CITY OF ALBUQUERQUE

April 7, 2017

Desert Ridge Place Unit 3

Re: Drainage Ordinance (14-5-2-1) Violations for Erosion and Sediment Control

**DESERT RIDGE PLACE UNIT 3**  
**TEMPORARY EROSION CONTROL PLAN MAP**  
 PROJECT TITLE

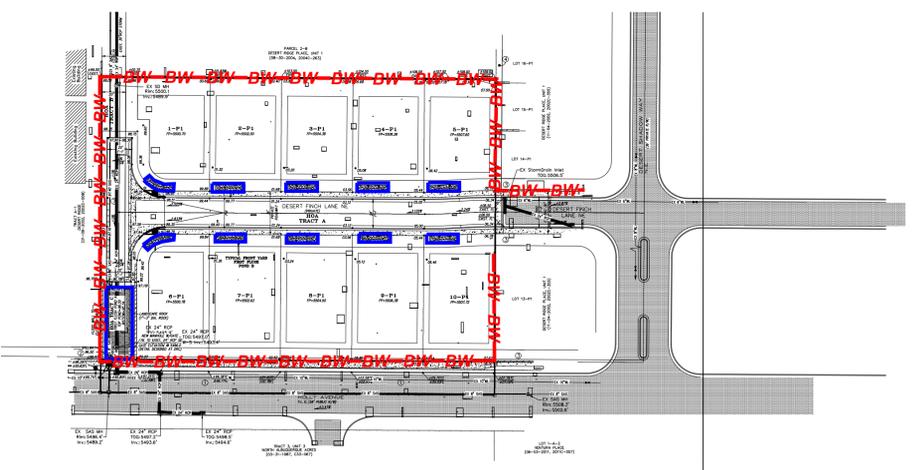
1. Silt fence wasn't buried.
2. There was a gap at the outfall location. The site drains to this location.

At today's inspection, the silt fence wasn't buried at the outfall location and dirt was piled against the fence sporadically and was not buried. There is a difference between burying the silt fence and piling dirt against it. See detail on approved plan.

1. Install/reinstall silt fence per approved methods. See approved ESC Plan.
